# CITY OF ALBUQUERQUE

January 11, 2016

**RE: Presbyterian Rev. Hugh Cooper**  
**Grading Plan (Stamp Date 12/7/2015)**  
**Hydrology File: B17D003**

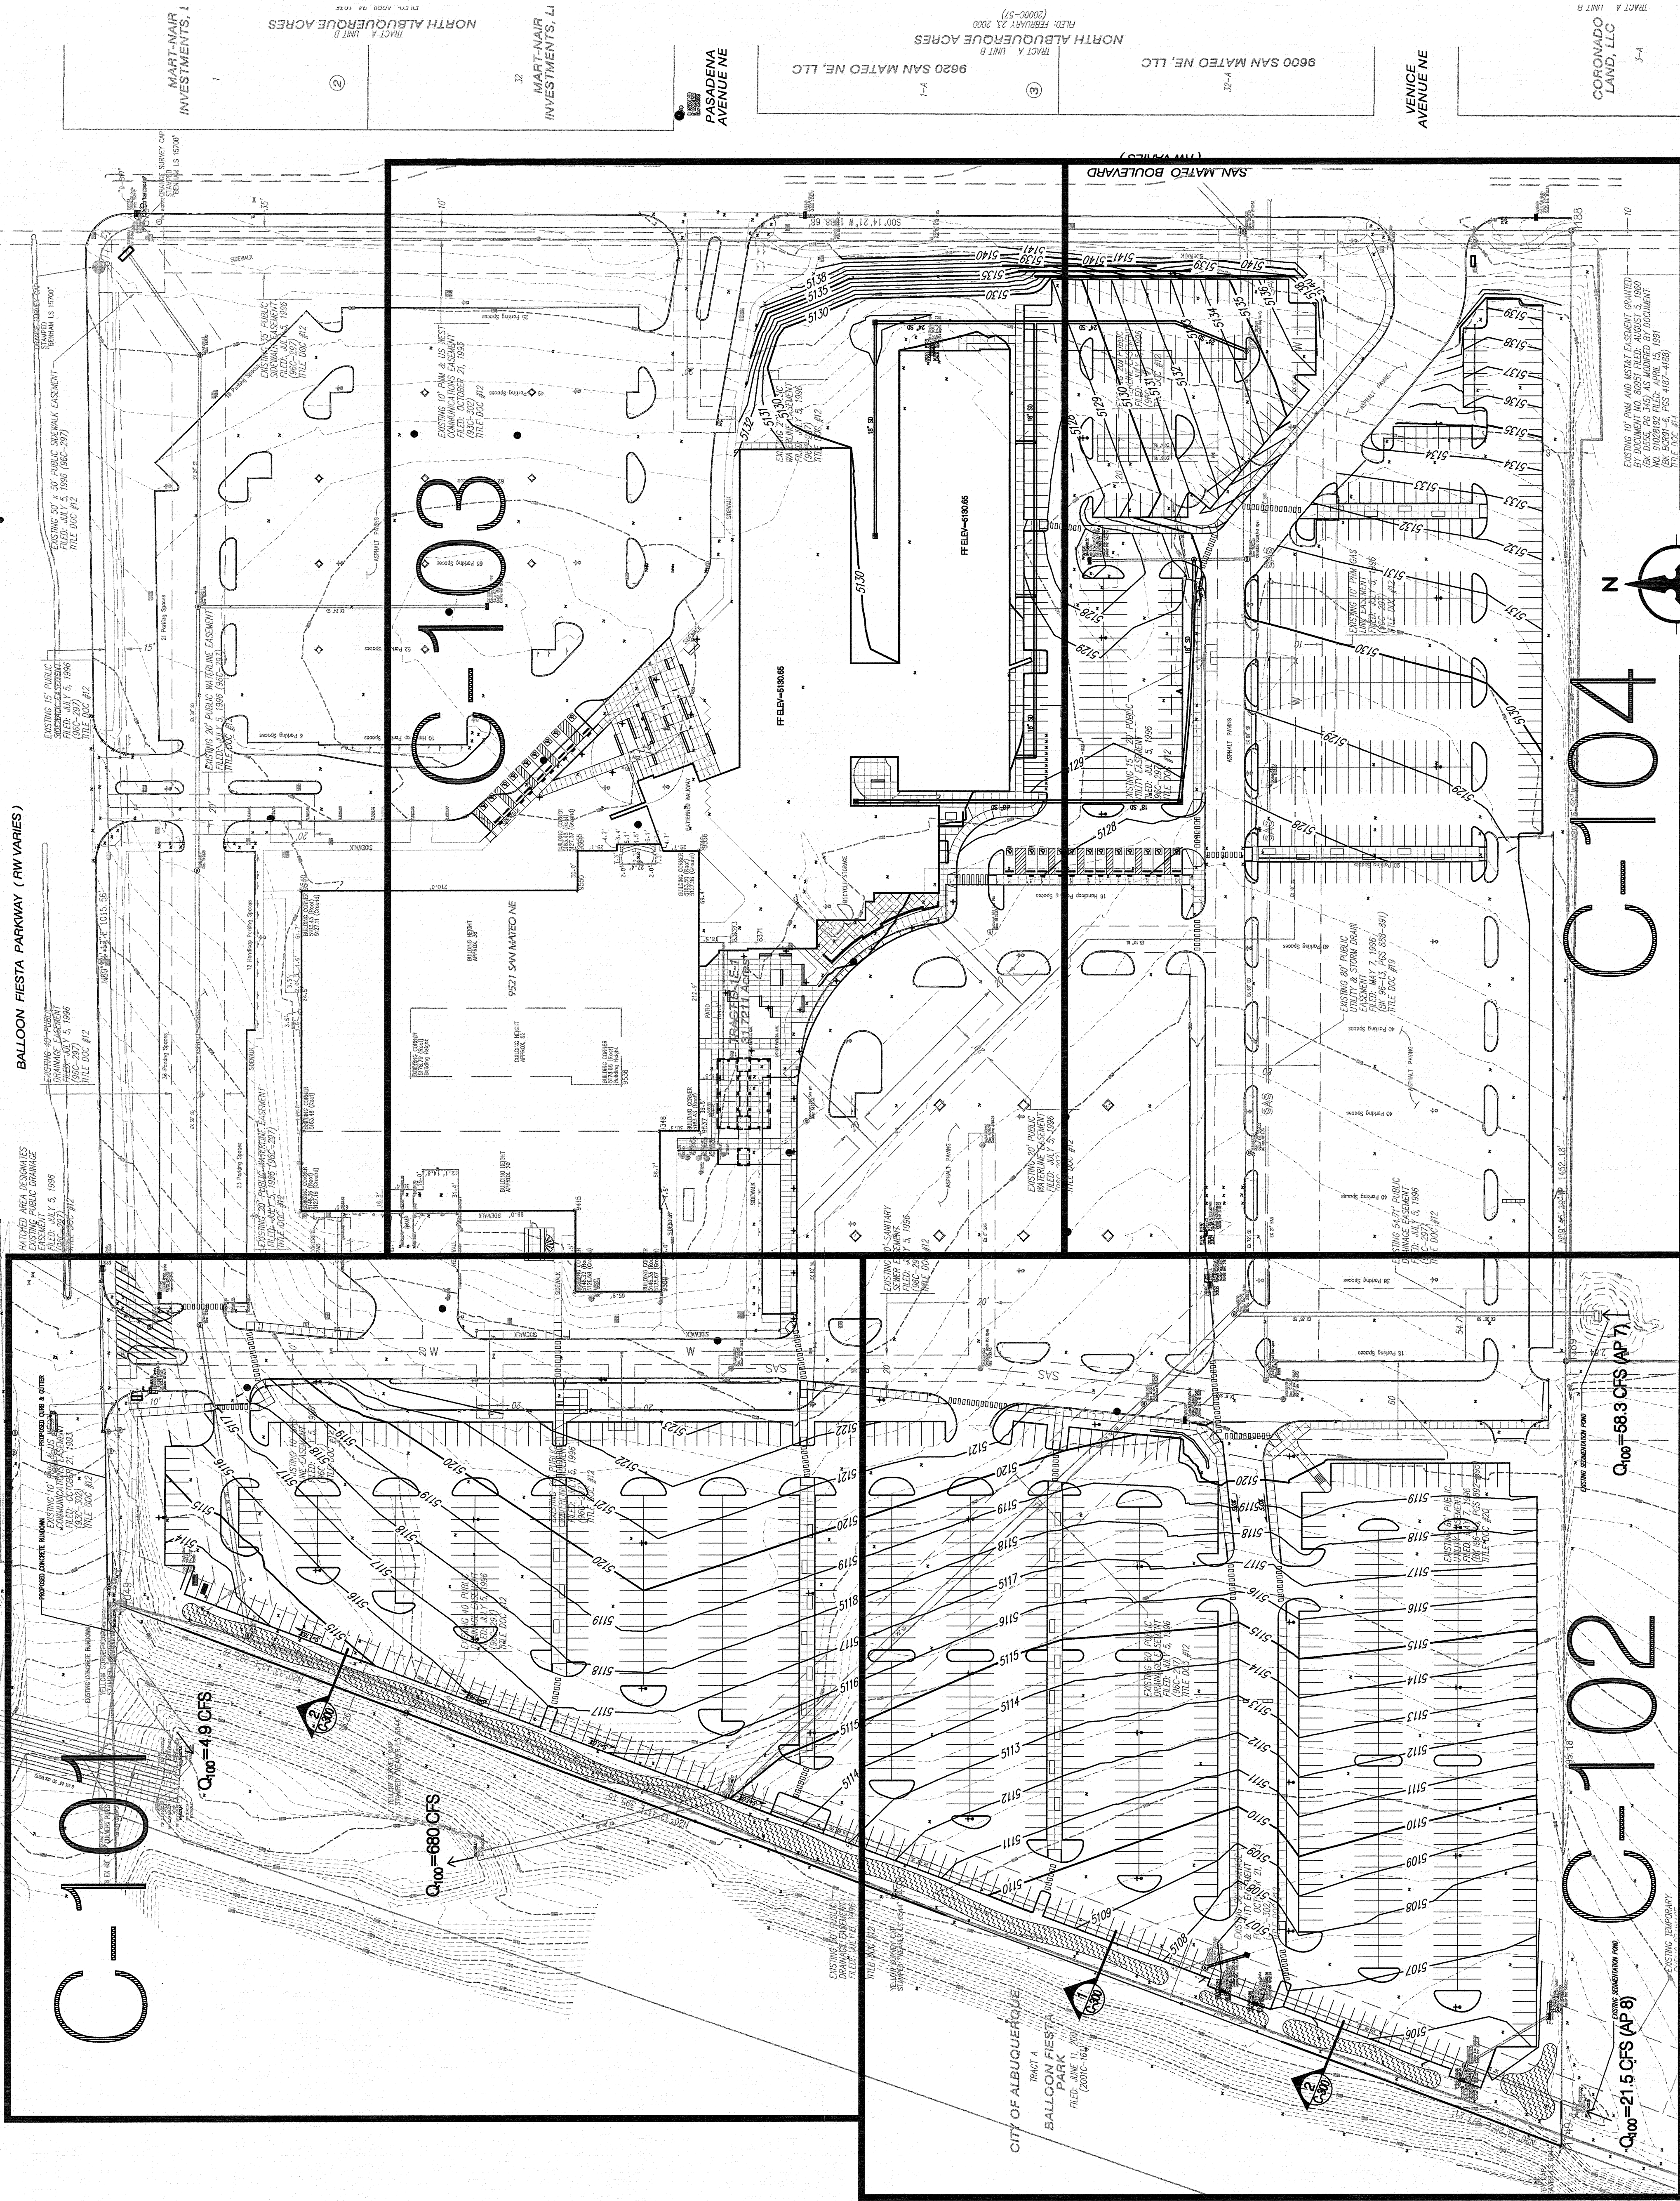
As previously discussed, we will expect to coordinate a storm water treatment feature for the parking lot outlet to maximize the compliance with the First Flush ordinance prior to Building Permit approval.
